Item No. **Report of the Head of Planning, Building Control, Sport & Green Spaces**

Address 150 JOEL STREET NORTHWOOD

Development: Change of Use of first floor one bedroom flat to staff room and classroom in connection with use as a nursery and provision of an additional vehicular access and outdoor play-space

LBH Ref Nos: **698/APP/2017/3447**

FIRST FLOOR PLAN

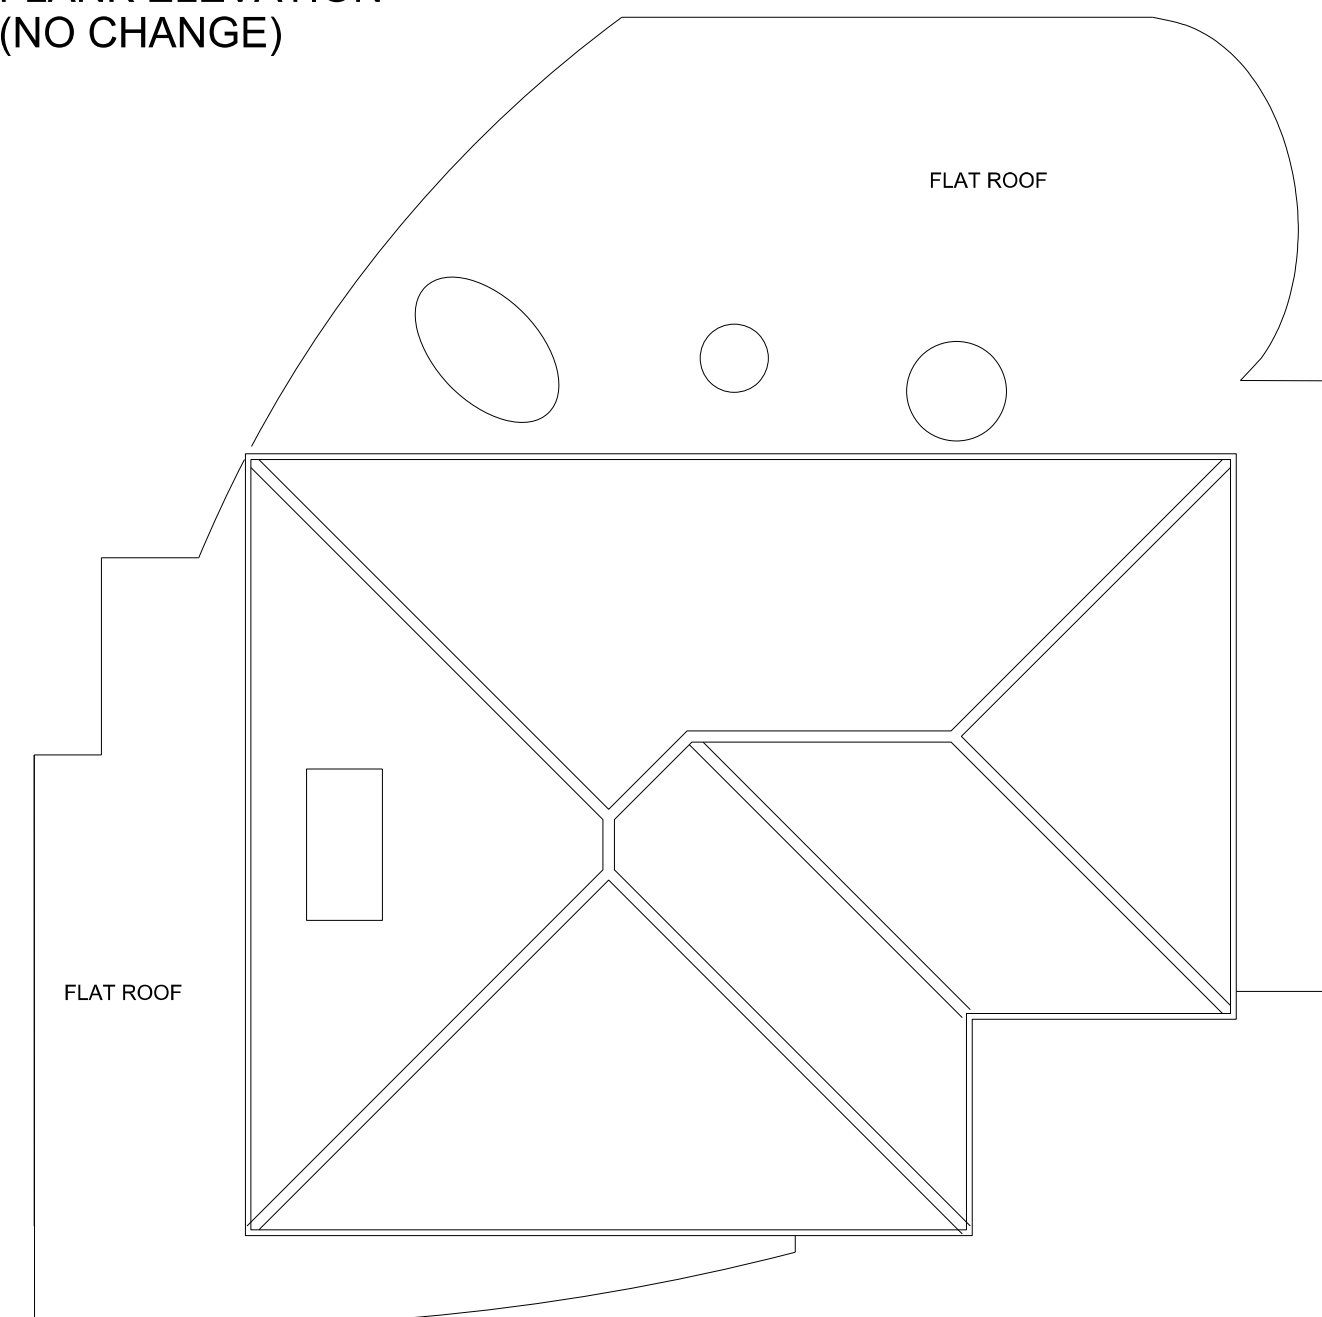
The existing flat is part of the change of use of the property to a nursery that was granted under planning application reference 698/APP/2011/2951. The loss of the residential unit is contrary to local and London wide policy and the intensified use of the site is considered likely to result in an unacceptable impact on adjacent occupiers. For the reasons set out in this report the application is therefore recommended for refusal.

The proposal would result in the loss of residential accommodation which is suitable with or without adaptation for residential use and which makes a contribution to the boroughs' housing stock. Therefore, the proposal is contrary to Policies H2, H3, R12 and R13 of the Hillingdon Local Plan: Part Two - Saved UDP Policies (November 2012) and Policy 3.14 of the London Plan (March 2016).

However these arguments relate to the occupation of the residential unit by persons unrelated to the building's nursery use. The approved plans for the unit under application reference 698/APP/2011/2951 clearly state it is intended as the 'Resident Manager's Flat' (approved plan reference 1129: 2.01 Rev A) and the approved Design and Access Statement includes the following:

In addition, the Description of Development for the application included the following text 'retention of a one bed staff flat at first floor level'. There is no separate access to the first floor and without a separate access, the one bedroom unit is considered ancillary to the main Class D1 use.

The evidence provided regarding the unsuitability of the unit for open market residential use is not therefore deemed sufficient justification given that the unit was approved as ancillary to the main use of the building and clearly proposed for staff accommodation and

Therefore the loss of all residential use on the site is deemed to be contrary to policy and the principle of the proposal is not supported.
